CITY OF ALBUQUERQUE

Re: Barlow Shop
6205 Wilshire Ave NE
Traffic Circulation Layout
Engineer's/Architect's Stamp 12-11-19 (C18D070)

Based upon the information provided in your submittal received 1-15-19, the above referenced plan cannot be approved for Building Permit until the following comments are addressed:

Project number 019.12
Date 12-11-19
Drawn by BEM
Checked by CMO

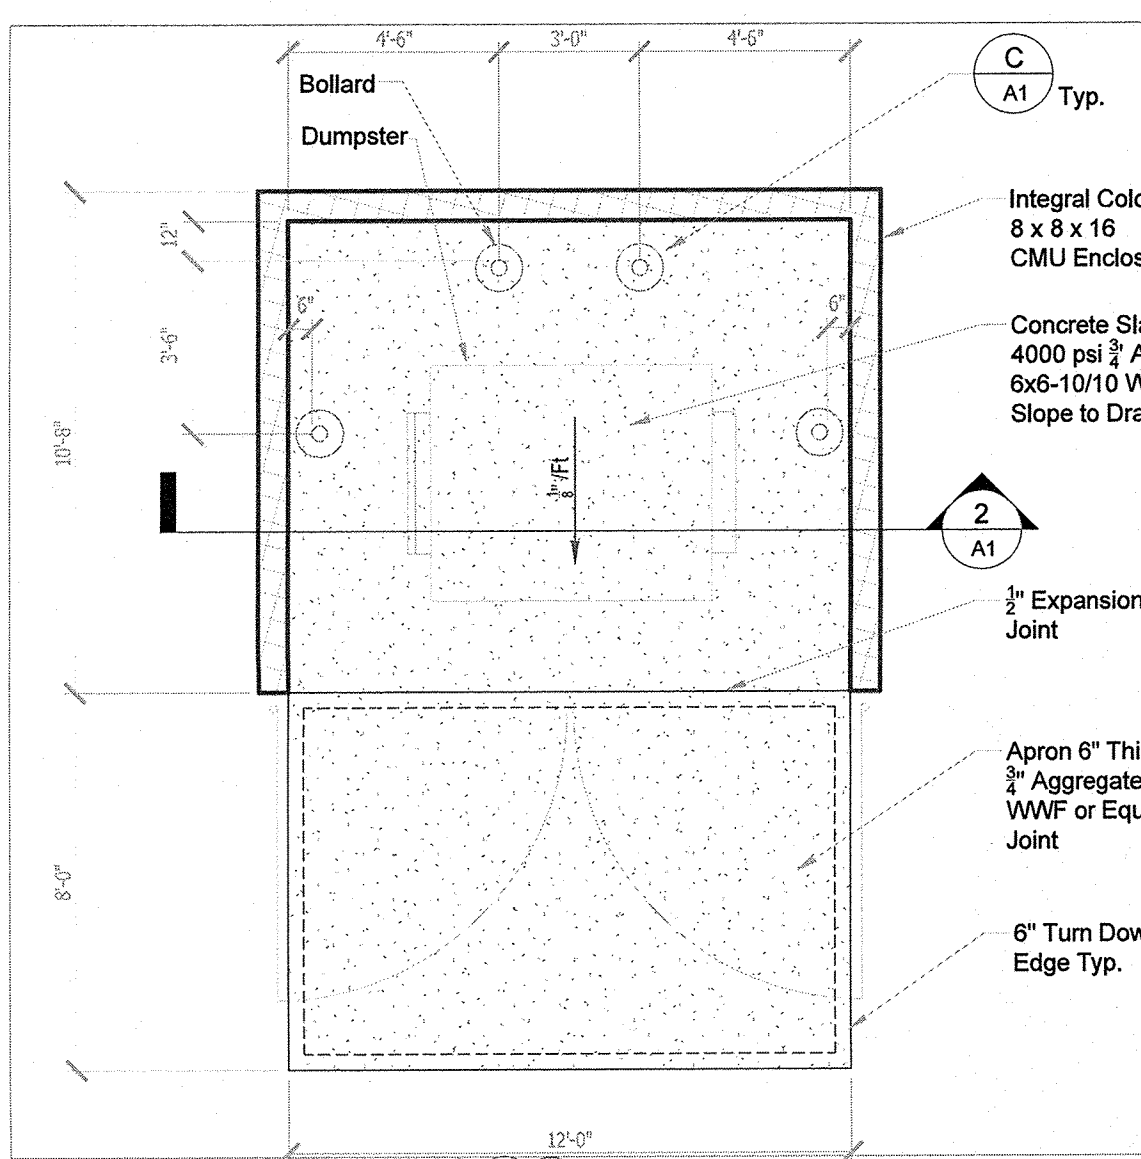
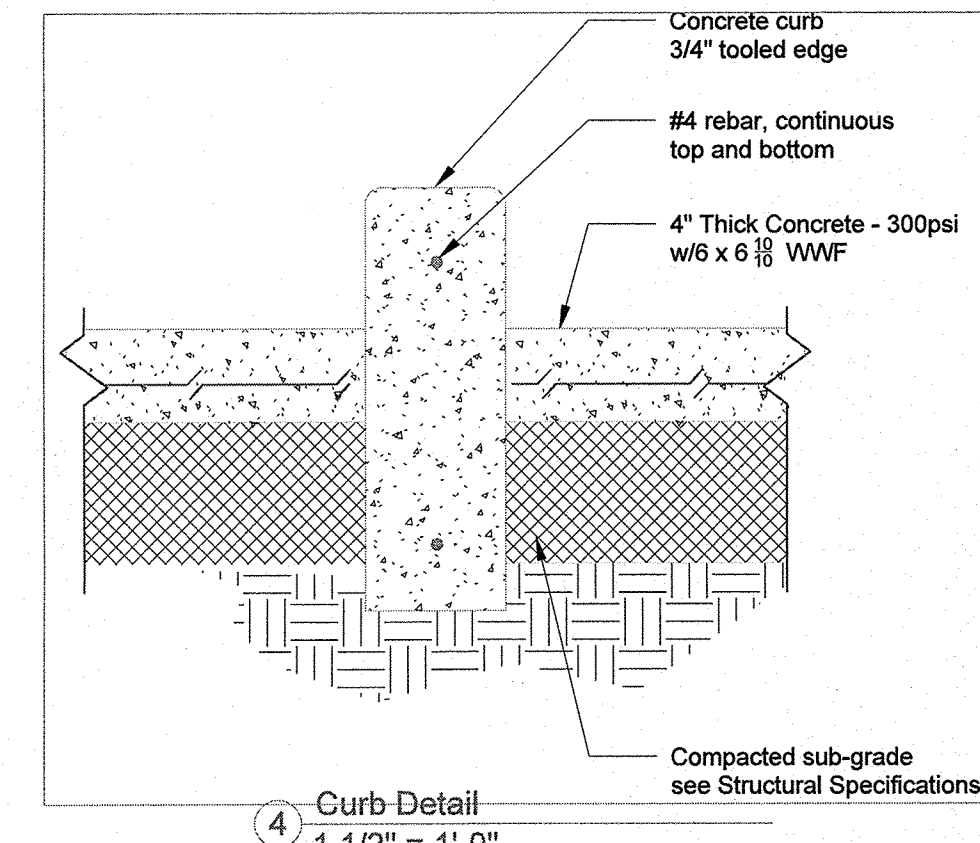
1. List the number of parking spaces required by the IDO as well as the proposed number of parking spaces including bicycle and motorcycle parking.
2. Please call out on TCL location of Bike Rack.

3. The ADA accessible parking sign must have the required language per 66-7-352.4C NMSA 1978 **"Violators Are Subject to a Fine and/or Towing."** Please call out detail and location of HC signs.

4. Each Motorcycle parking space shall be designated by its own conspicuously posted upright sign, either free-standing or wall mounted per the IDO. Please add sign detail.

5. Per the IDO, a 6 ft. wide ADA accessible pedestrian pathway is required from the public sidewalk to the building entrances. Please clearly show this pathway and provide details.

6. Per DPM, a 6 ft. wide ADA accessible pedestrian pathway is required from the HC parking stall access aisles to the building entrances. Please clearly show this pathway and provide details.

7. Service vehicle and/or refuse vehicle maneuvering must be contained on-site; provide a copy of refuse approval.
8. Add the following note to the plan for the Clear Site Tringle: "Landscaping and signage will not interfere with clear sight requirements. Therefore, signs, walls, trees, and shrubbery between 3 and 8 feet tall (as measured from the gutter pan) will not be acceptable in the clear sight triangle."

9. Please specify the City Standard Drawing Number when applicable. Please add Sidewalk City Standard #2430, Curb and Gutter City Standard #2415 & Drive Access City Standard #2425 and add detail for ADA compliance.
10. Please add Truncated domes to ramps located in the Public Right of Way.
11. Provide notes showing what work is included and on the work order and the private work on site.
12. Please add a note on the plan stating "All improvements located in the Right of Way must be included on the work order."
13. Please indicate transition from ADA access aisle to building entrance.
14. Please include one copy of the traffic circulation layout at the next submittal.
